Planning Application No: 3/2026/0049

Proposal: Demolition of existing side car port with erection of single-storey rear extension and two-storey side extension with integral garage.

Location: 11 St Peters Close Clayton le Dale BB1 9HH

Tahira Akhtar BA (Hons)
Technician
Highway Development Control
Highways & Transport
Lancashire County Council

**PROPOSED GROUND FLOOR PLAN**  
1 : 50

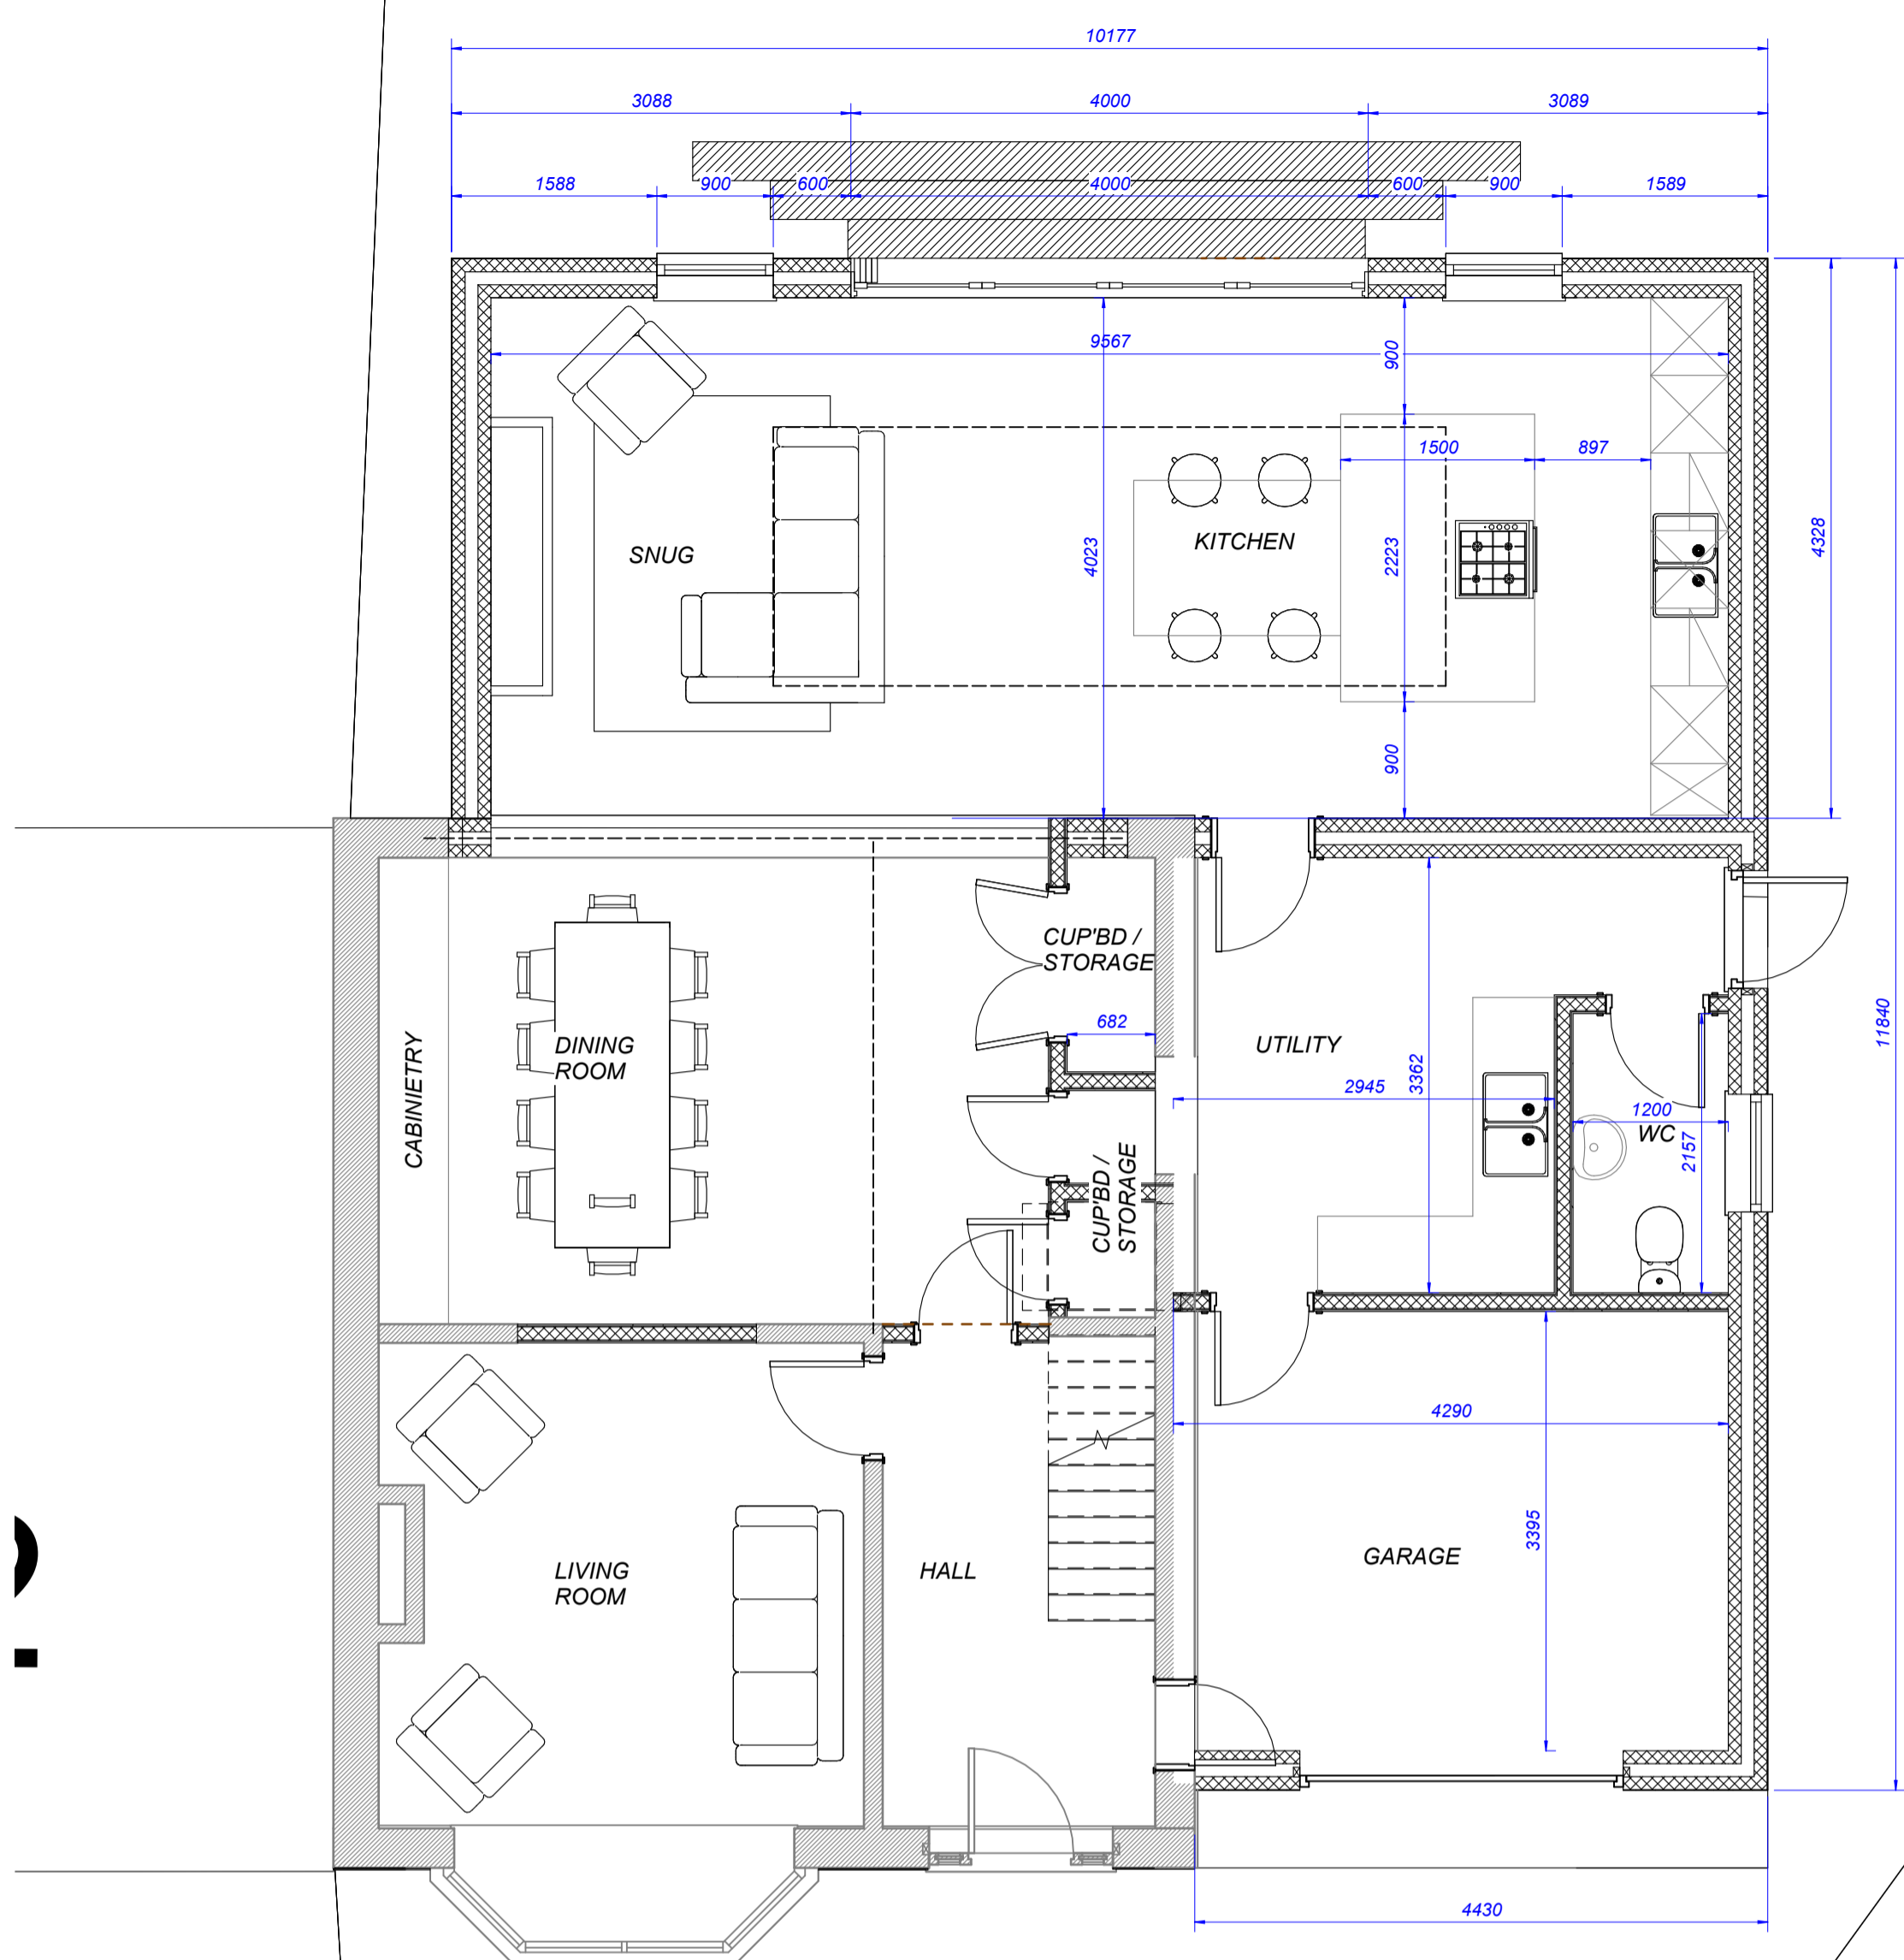
The integral garage suitable for cycle storage but substandard for car parking. However, 3 parking spaces can be provided for this proposal on the drive. This meets parking standards requirements therefore, no objection on highway grounds.
